Kirklees Council
Planning and Development Service
PO Box 1720
Huddersfield
HD1 9EL

Date: 23-Dec-2024
Our Ref: 2024/93077

**Discharge details reserved by conditions 15 (waste/recycling facilities), 16 (charging electric vehicles), 17 (landscaping), 18 (residential amenity) on previous permission 2020/91601 for change of use from agricultural land to Sui generis Drinking Establishment (previously A4) and erection of extensions and alterations Dunkirk Inn, 231, Barnsley Road, Lower Denby, Huddersfield, HD8 8TX
Application Number: 2024/93077**

Drawing DC02
 External Landscaping Works and Residential
 Amenity Protection Measures
 at
 The Dunkirk Inn, 231 Barnsley Road, HD8 8TX

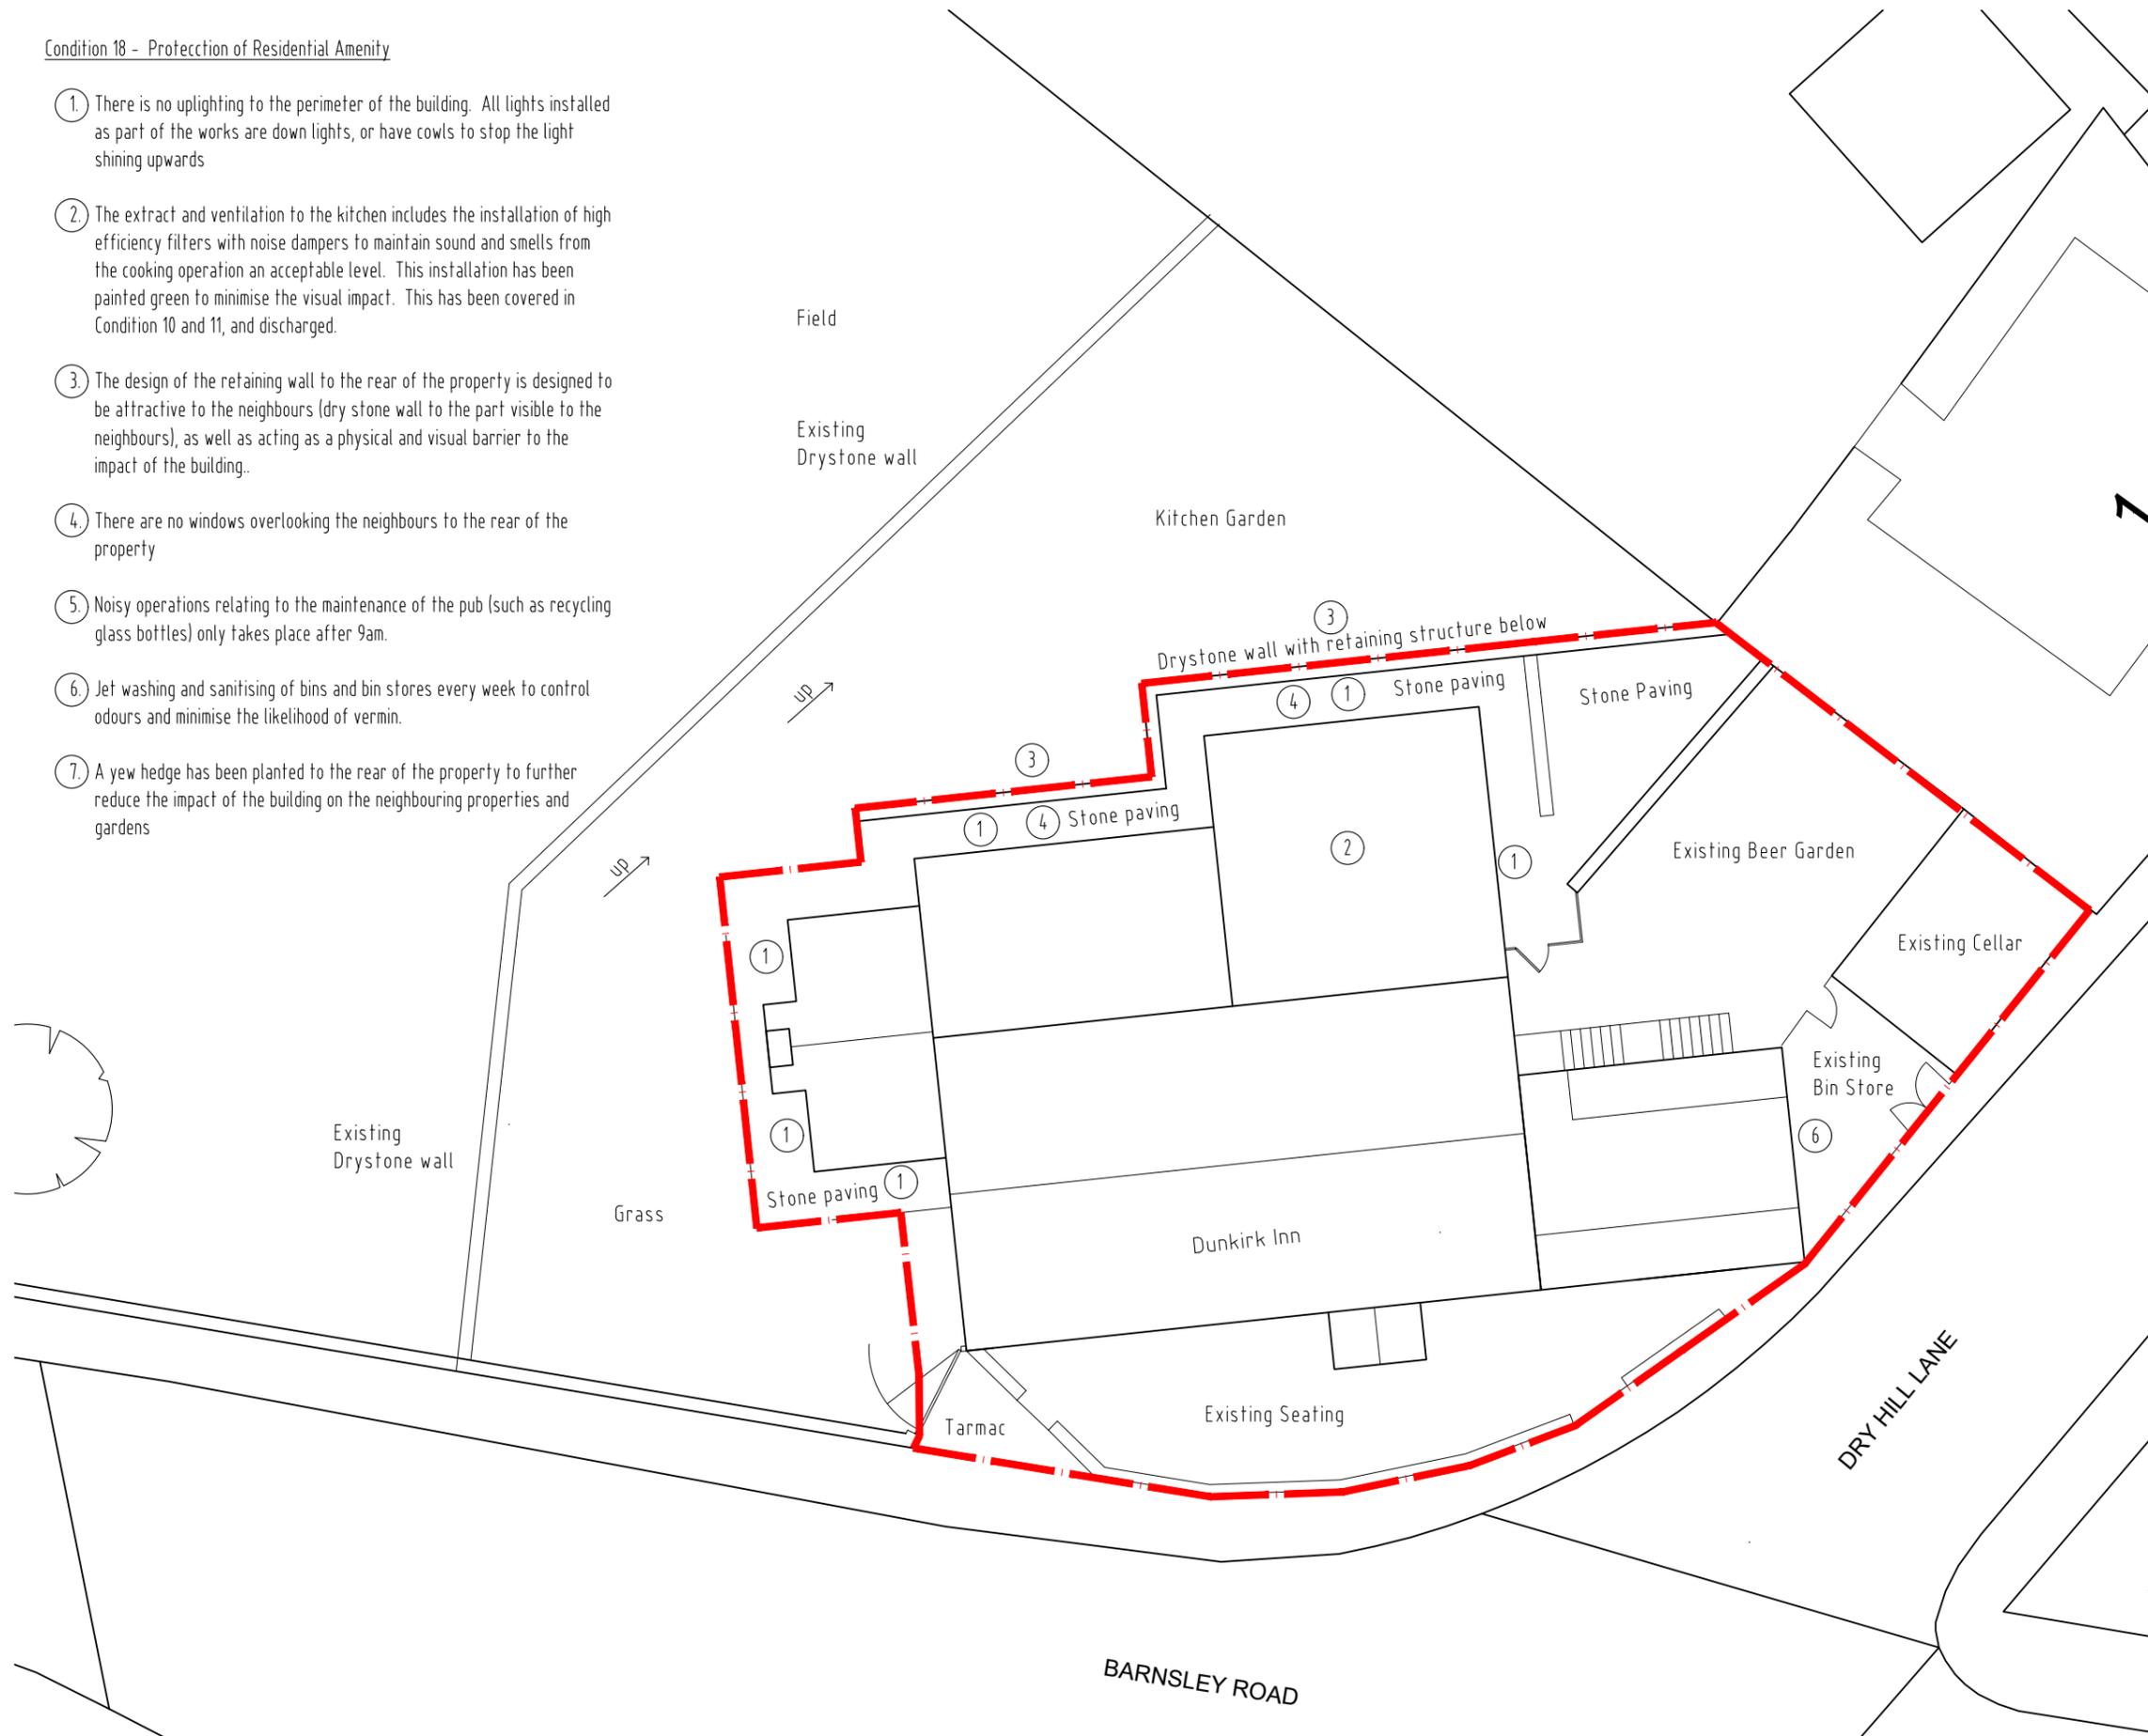
The details provided have been reviewed with KC Environmental Health and are considered acceptable

Drawing DC01  
Electrical Vehicle Charging and Recycling Facilities  
at  
The Dunkirk Inn, 231 Barnsley Road, HD8 8TX

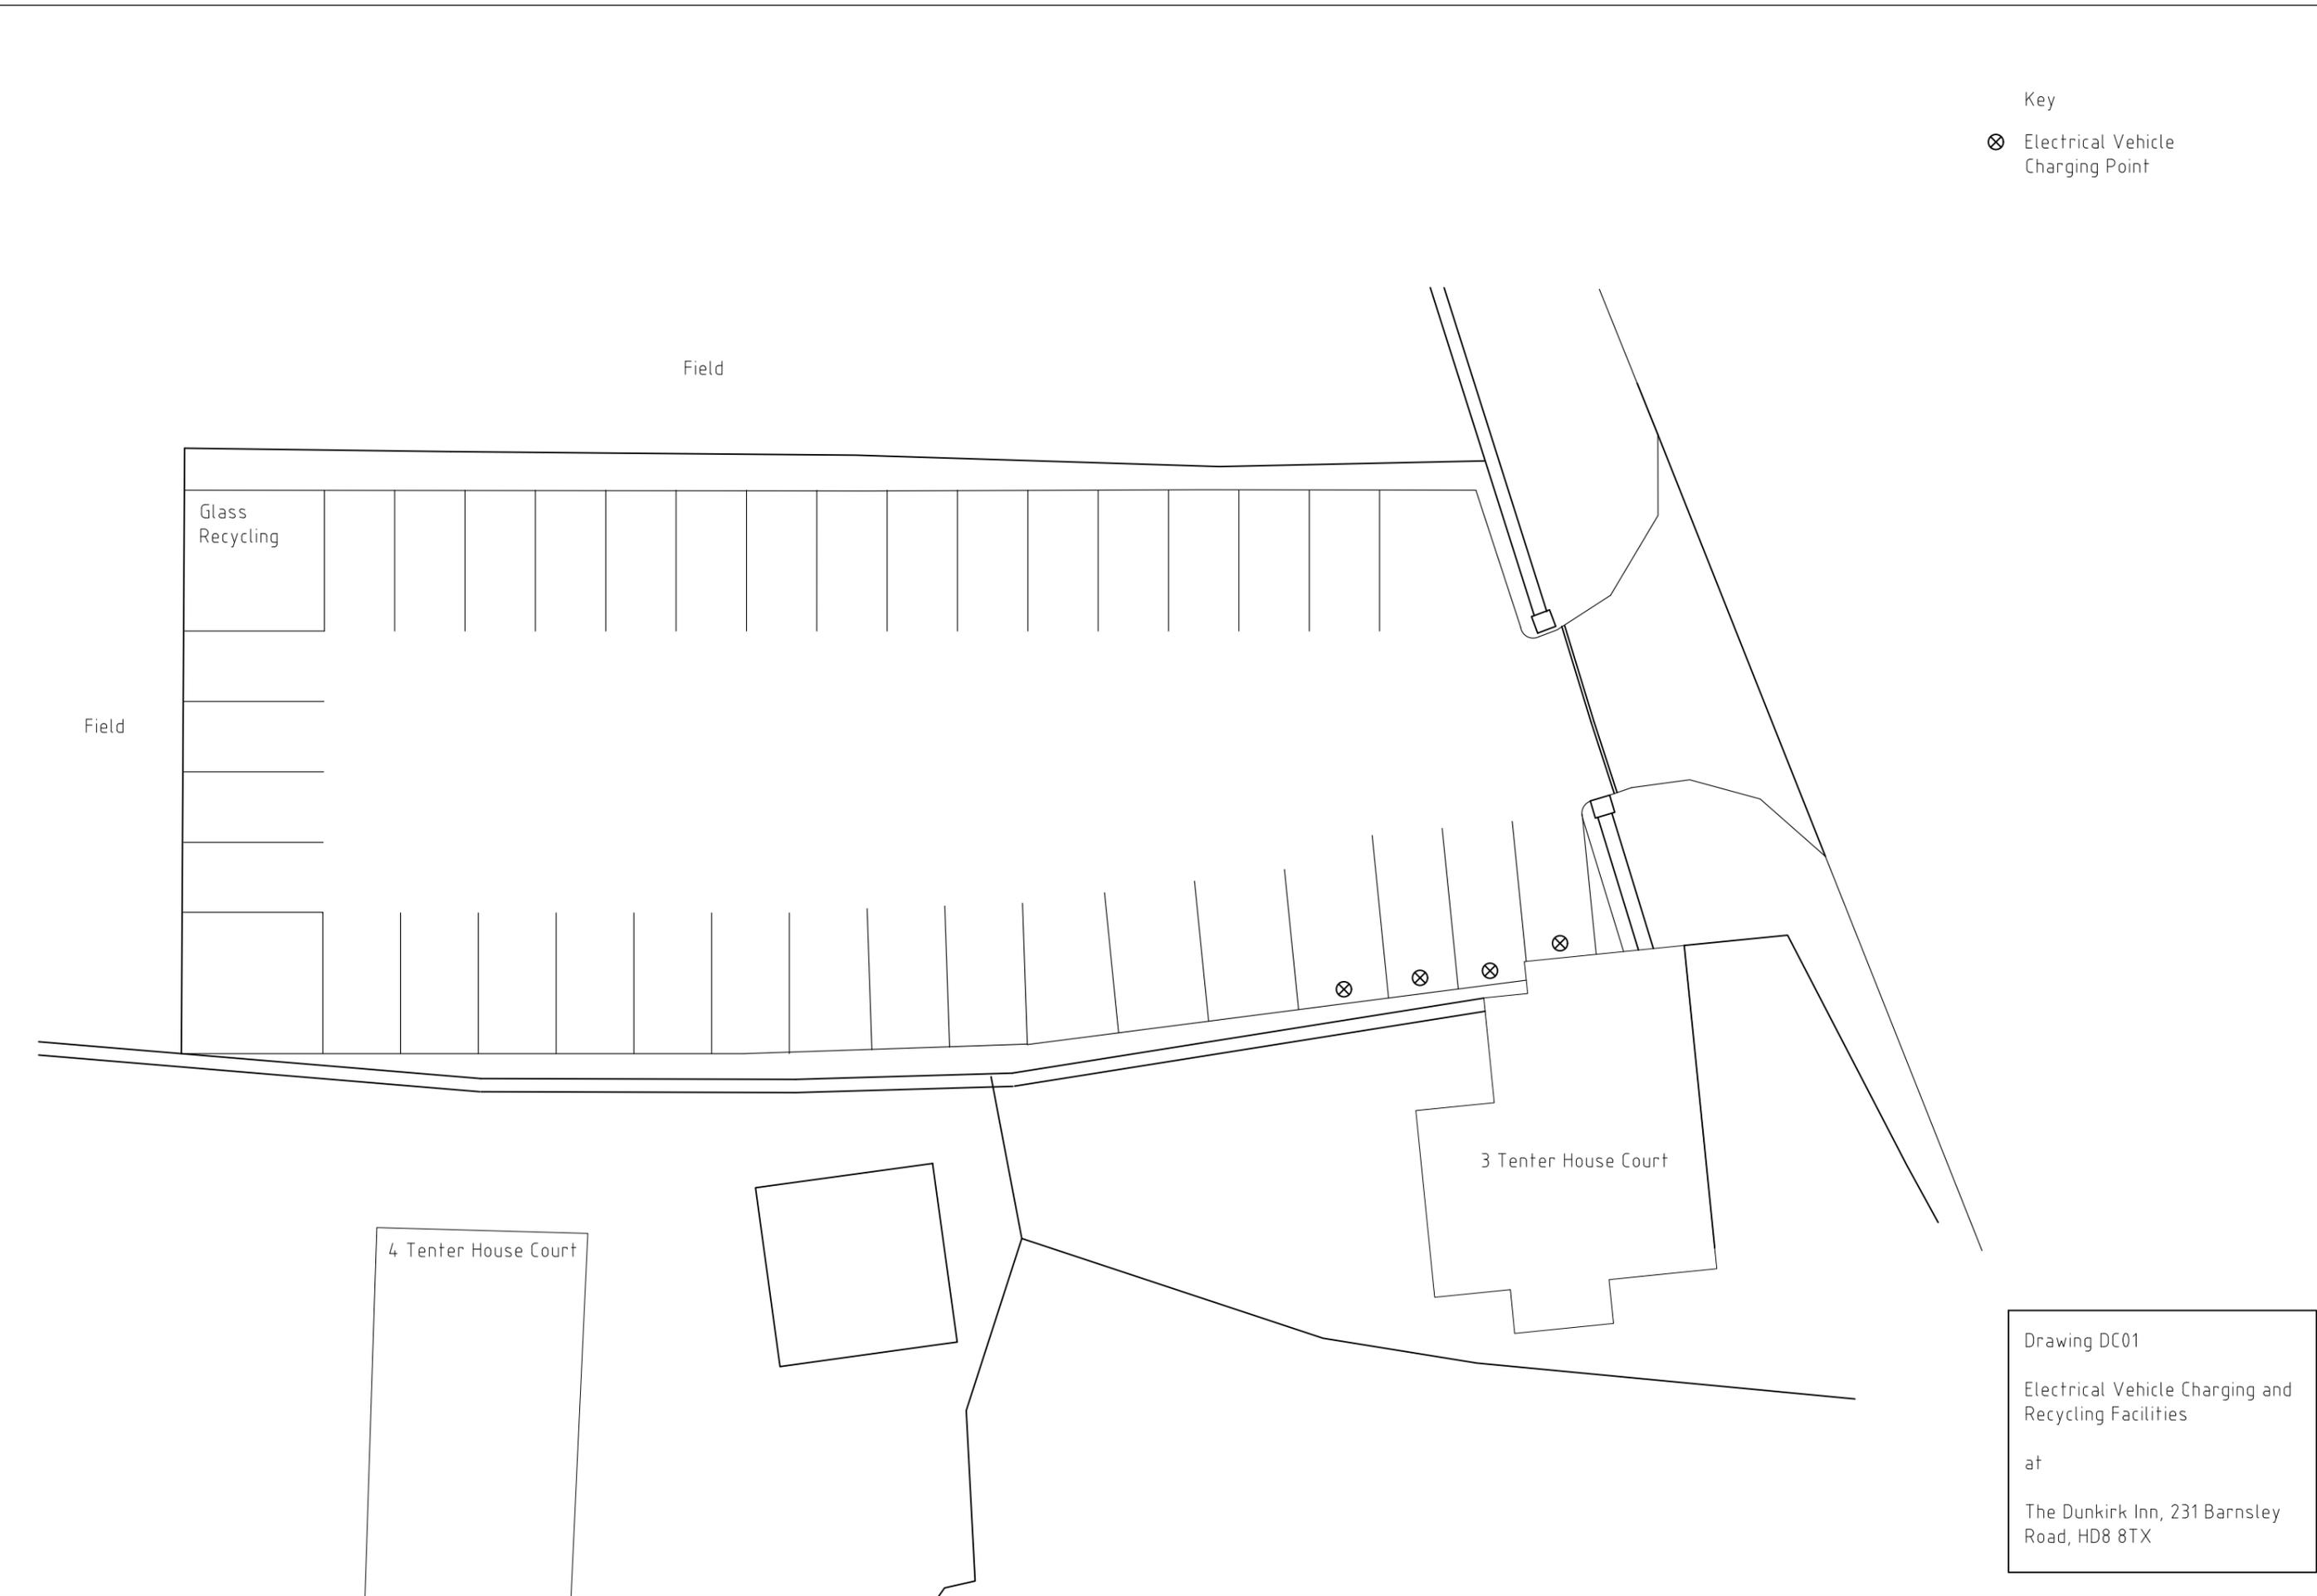
The submitted drawings indicate four electric charging points would be installed in the car park of the site,

The applicant is reminded that the electric charging points are to be retained for the lifetime of the development.
